CITY OF ALBUQUERQUE

**RE: Carlisle Marketplace
2100 Carlisle NE
Conceptual Grading Plan Stamp Date: 8/21/19
Drainage Report Stamp Date: 8/28/19
Hydrology File: H17D097**

Based on the submittal received on 9/4/19, the Conceptual Grading and Drainage Plan cannot be approved until the following are corrected:

| REVISION                                                                                               |                      |         |           |
|--------------------------------------------------------------------------------------------------------|----------------------|---------|-----------|
| SHEET NUMBER:                                                                                          | C-100                |         |           |

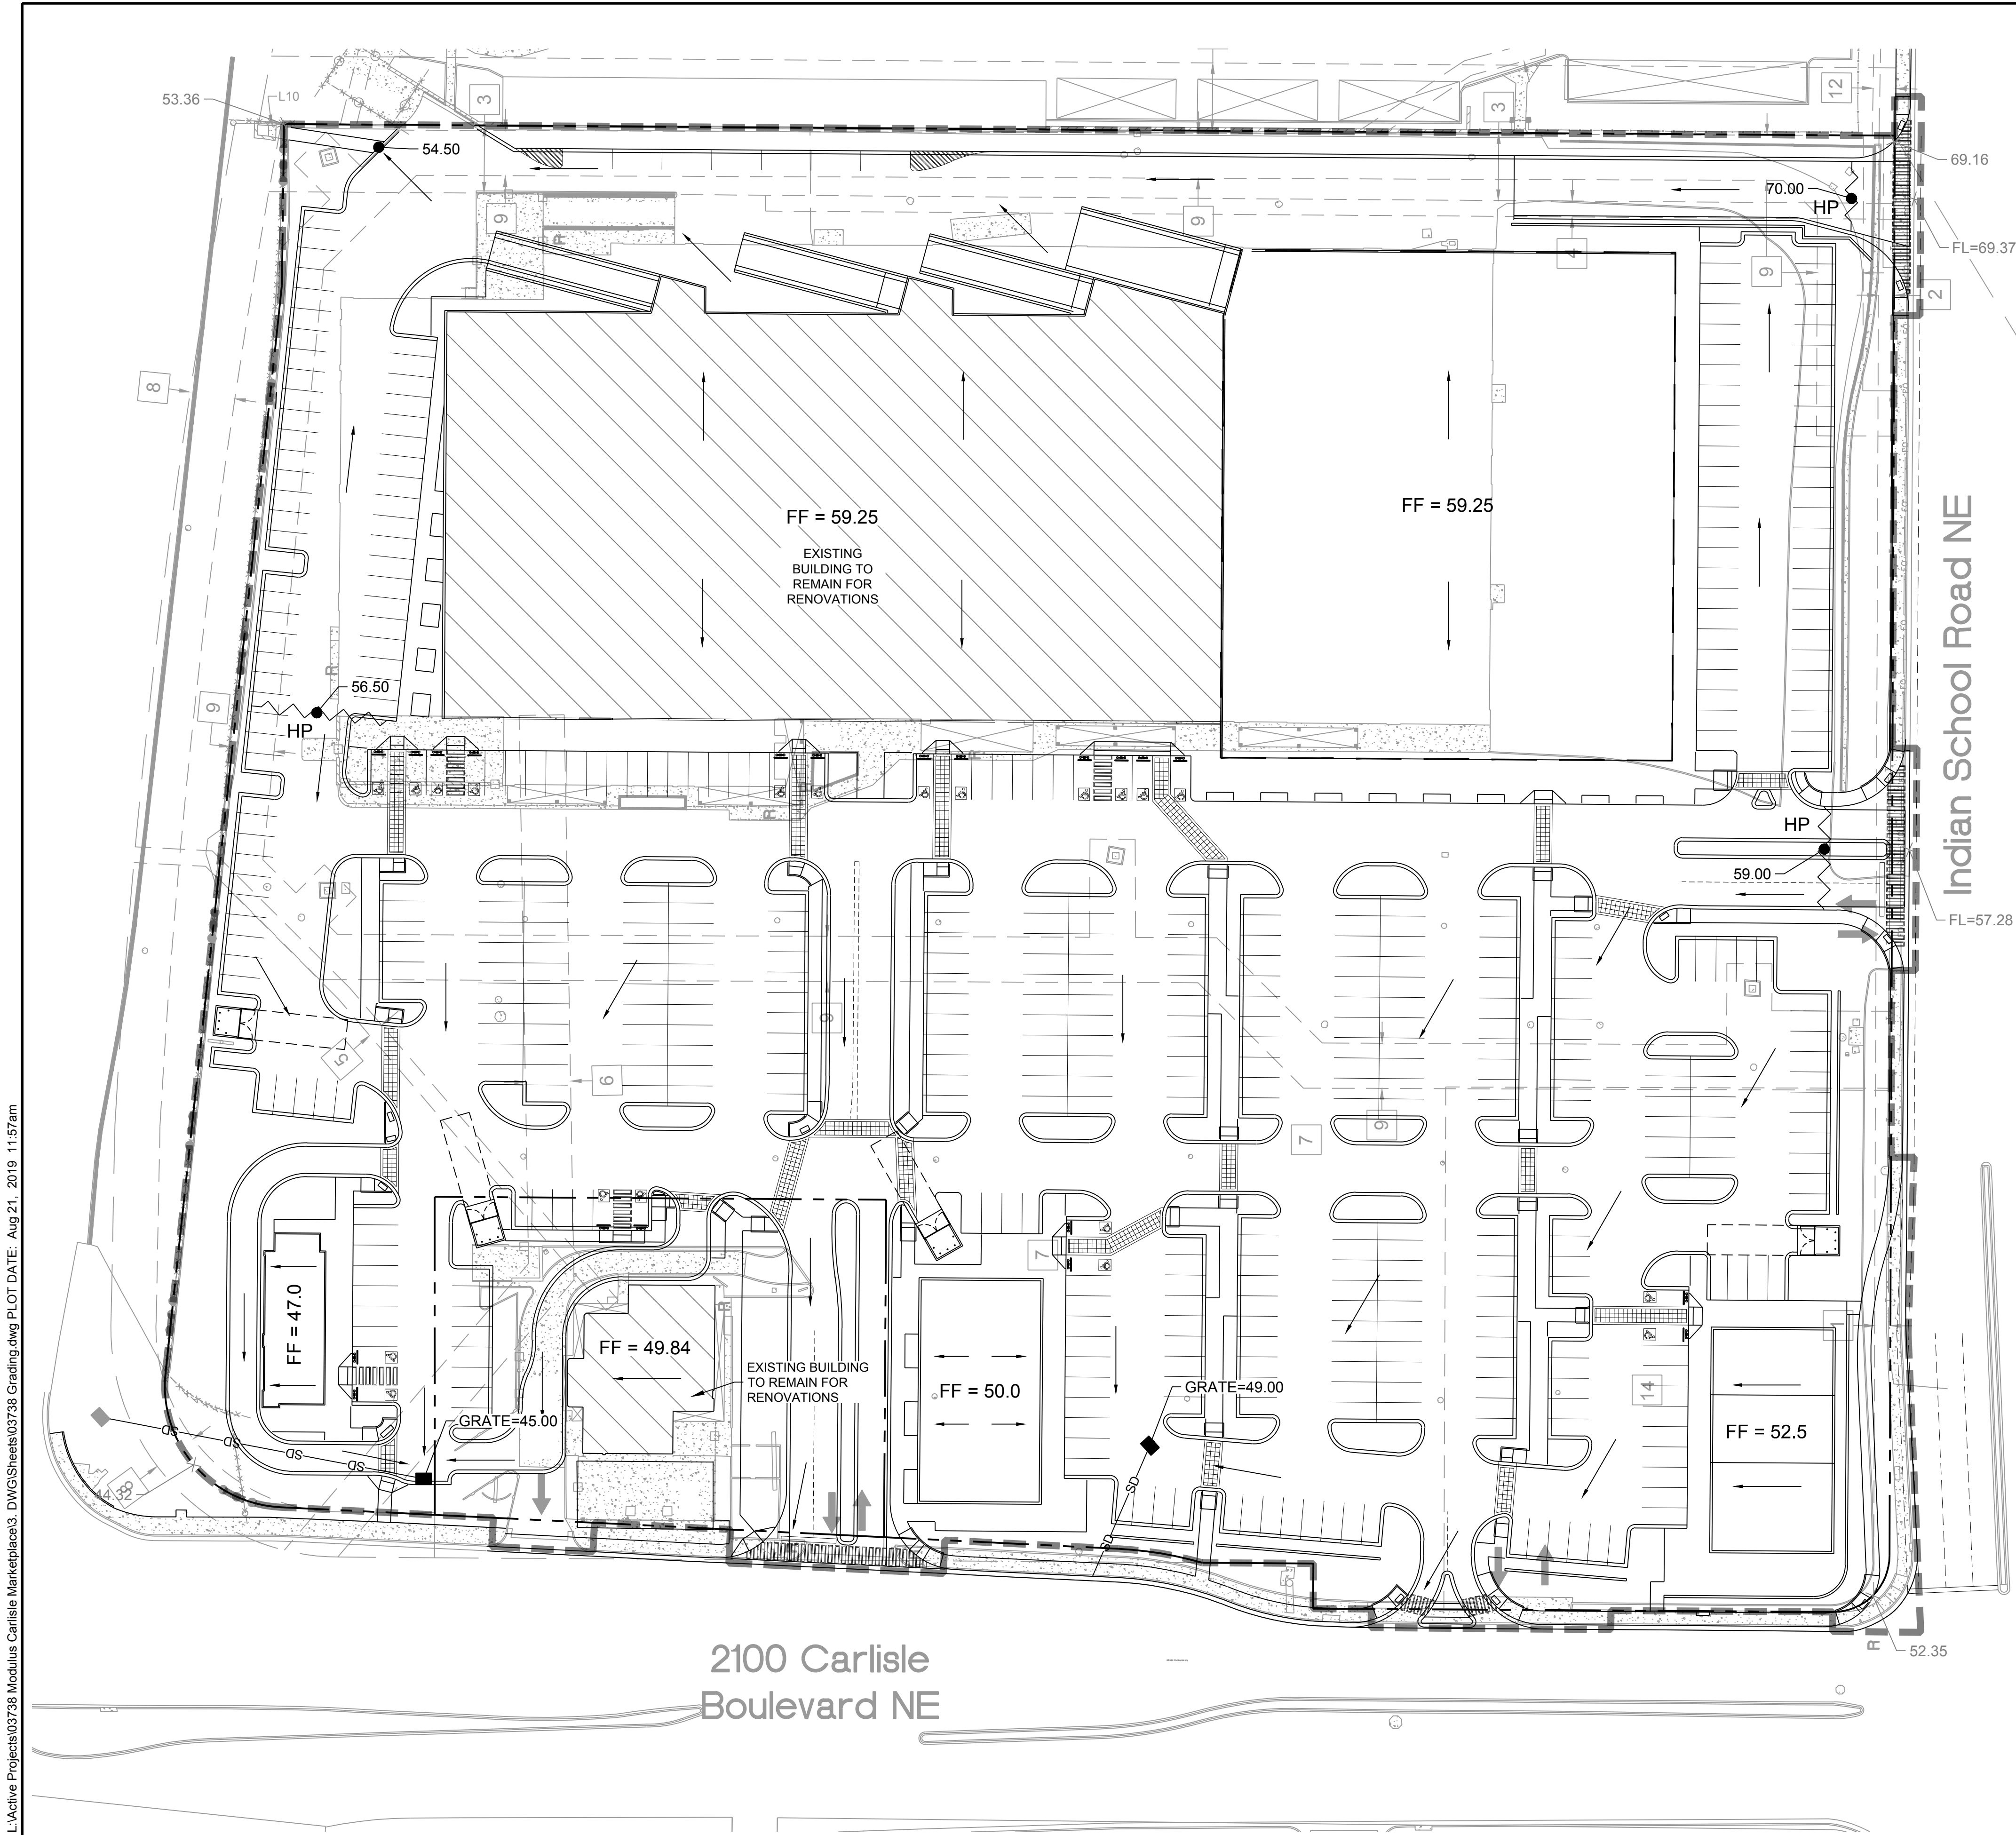
1. Show the grading for the new ramp up to Indian School in the SE corner of the lot; the proposed contours do not make sense in this area. Show the fire hydrant relocation, retaining walls to be removed, retaining walls to be constructed, top of wall and bottom of wall elevations, and any ROW improvements such as a right turn bay on Indian School. Provide a waterblock, at least 0.87' high at the entrance.

2. The grading for the adjacent new parking lot seems to be missing too. Provide drainage conveyance from this parking lot, in between the ramp and the new building, and out to the NE corner, allowing all of subbasin 2 to drain per the proposed drainage report. A concrete channel is likely needed between the ramp and the building.

6. The storm drain (inlets manholes, pipes, inverts, etc...) in Carlisle and I-40 frontage needs to be surveyed and shown on the grading plan.
7. Required SWQV needs to be calculated for the impervious area only and using the redevelopment amount (0.26/12"). It looks like you multiplied .34/12" by the impervious area.

9. Payment in Lieu of onsite management of the SWQV must be made prior to Building Permit (Amount T.B.D).
10. Please show and label the pond(s) and include a label on each with the SWQV and elevation, the 100-year volume and elevation, the peak 100 year inflow and outflow, the spillway crest elevation, and the spillway flow depth.
